West Burton Solar Project

Draft Statement of Common Ground with Natural England

PINS reference: EN010132
Document reference: EX1/WB8.3.7

### Figure 8.18.1: Landscape and Ecology Mitigation and Enhancement Measures West Burton 1

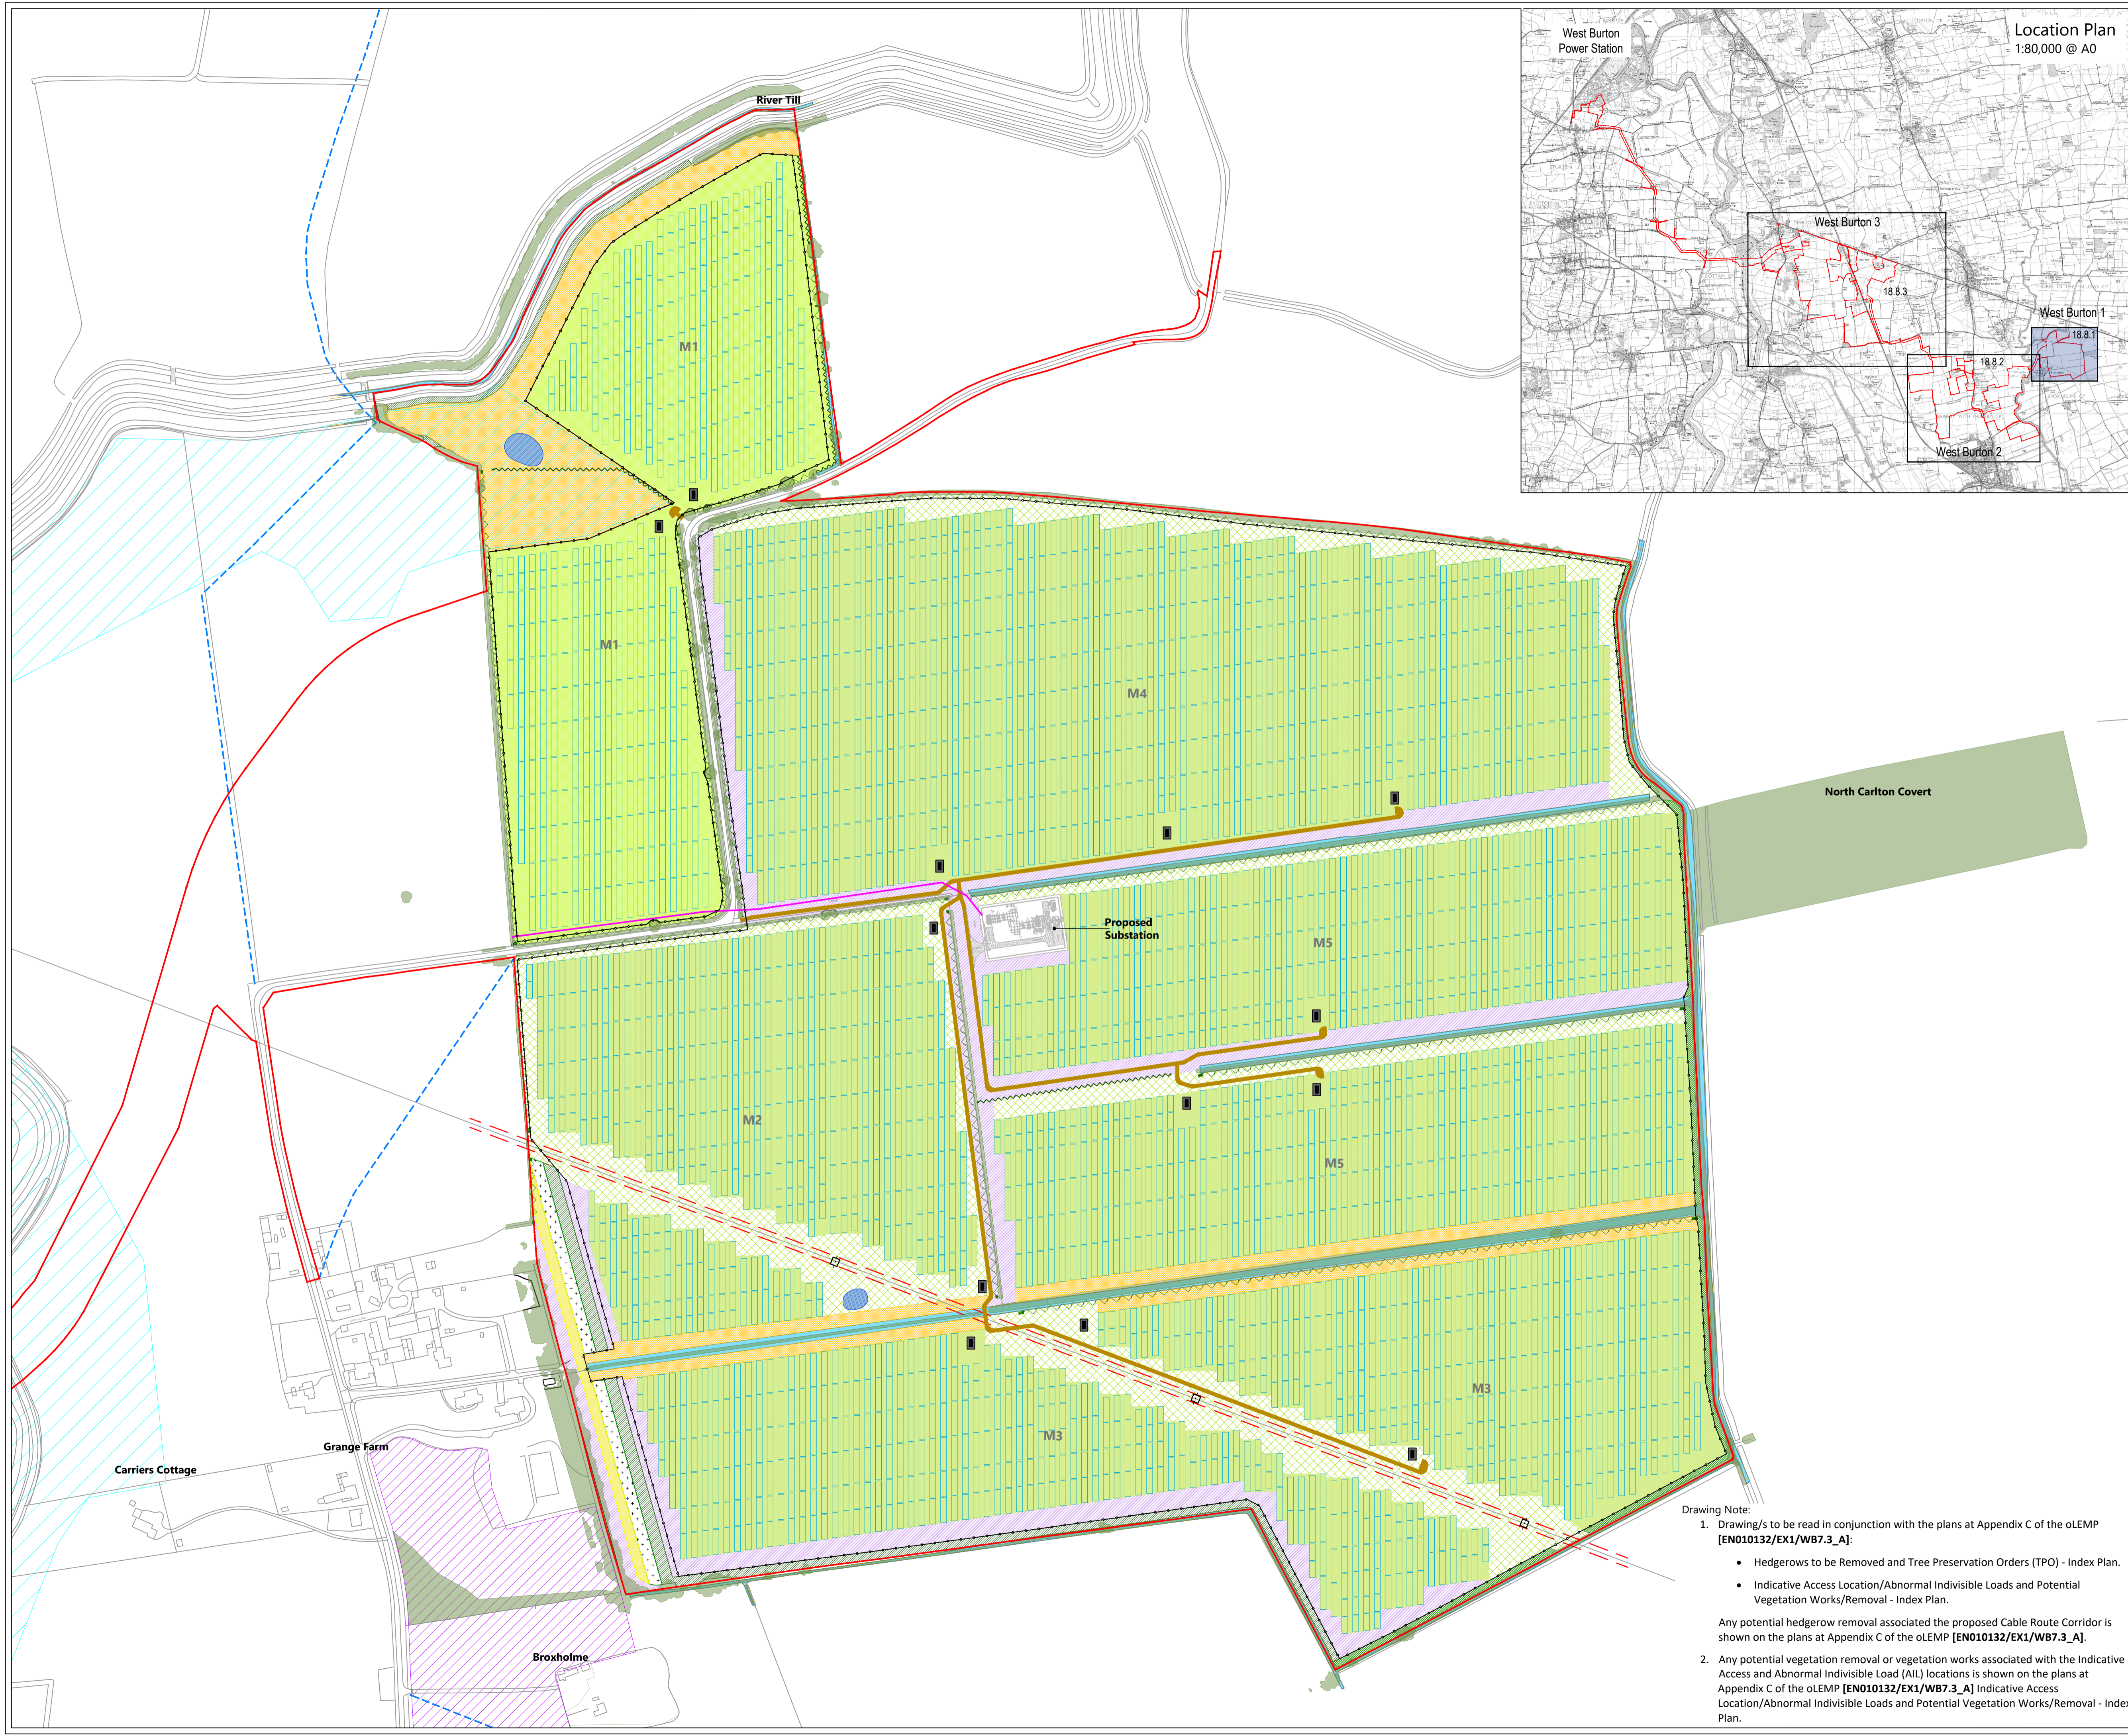
Main Topic	Sub-topic	Details of Matters Under discussion	
LAN-07 Landscape and Visual Impact	Public rights of way and access	<p>From PEIR Stage Submission – 27/07/22</p> <p><i>“Natural England note the intention to minimise impacts on, and enhance, the footpath network associated with the site, noted in paragraphs 8.9.90-110 of the PEIR. Where footpaths directly cross the site, as at West Burton 3 and 4, we welcome the intention to ensure panels are set back by at least 15m, and welcome the suit of primary, secondary and tertiary mitigation measures proposed to retain the value of these PRow. Where PRow enhancements are proposed, or other permissive routes are proposed, we would recommend that ecological enhancements in these areas could form the backbone of a network of green infrastructure throughout the sites. We particularly welcome the intention to create a new permissive path at West Burton 2 from Sykes Lane to Codder Lane Belt onwards to create a new circular route.”</i></p>	<p>The LVIA has carried forward the landscape mitigation from the PEIR, to 6.2.8 Environmental Statement - Chapter 8_Landscape and Visual Impact Assessment [APP-046], including the intention to enhance the footpath network associated with the Sites, where appropriate, noted as ‘secondary mitigation’ that includes the planting of new hedgerows and trees and the management of existing hedgerows. There are also ‘tertiary mitigation’ measures that recommend increasing accessibility and connectivity of PRow, but also measures to increase understanding of the local landscapes and the Scheme. Exact details of what these measures will be are still being considered by the Applicant. The LVIA also draws out ecological enhancement measures to underpin a wider public understanding of the Scheme and ensure that all identified impacts are minimised as far as possible on existing trees, hedgerows and other habitats. These measures are set out in 7.3 Outline Landscape and Ecological Management Plan [APP-311] and will be secured through Requirement 7 in Schedule 2 of 3.1 Draft Development Consent Order [APP-017]. These measures also include the permissive path secured through Requirement 17 of the Order.</p>

<p>Scheme Evolution: The Strategic Landscape Mitigation Measures have evolved since the PEIR submission, and more detail is now provided in the Landscape and Ecology Mitigation and Enhancement Plans (Environmental Statement - Figures 8.18.1 to 8.18.3 [APP-281 to APP-283]). These drawings take account of the offsets and buffers from the PRoW and ecological features.</p>
LAN-08 Landscape and Visual Impact	Connecting people with nature	<p>From PEIR Stage Submission – 27/07/22</p> <p><i>“Providing interpretation through signage or public consultation is noted within PRoW ‘Tertiary Mitigation’ for West Burton 1-4 (PEIR paragraphs 8.9.90-110). However little detail is provided. We would encourage the implementation of such measures, for example along circular routes which are anticipated to be used more frequently. The ecological enhancement measures which are being undertaken as part of the project could be summarised on information boards to provide public understanding of the project and encourage access to nature.”</i></p> <p>.</p>	<p>The LVIA has carried forward the landscape mitigation from the PEIR, to 6.2.8 Environmental Statement - Chapter 8_Landscape and Visual Impact Assessment [APP-046], including the intention to enhance the footpath network associated with the Sites, where appropriate, noted as ‘secondary mitigation’ that includes the planting of new hedgerows and trees and the management of existing hedgerows. There are also ‘tertiary mitigation’ measures that recommend increasing accessibility and connectivity of PRoW, but also measures to increase understanding of the local landscapes and the Scheme. Exact details of what these measures will be are still being considered by the Applicant. The LVIA also draws out ecological enhancement measures to underpin a wider public understanding of the Scheme and ensure that all identified impacts are minimised as far as possible on existing trees, hedgerows and other habitats. These measures are set out in 7.3 Outline Landscape and Ecological Management Plan [APP-311] and will be</p>

secured through Requirement 7 in Schedule 2 of 3.1 Draft Development Consent Order [APP-017]. These measures also include the permissive path secured through Requirement 17 in Schedule 2 of the Order.
--	--	--	--
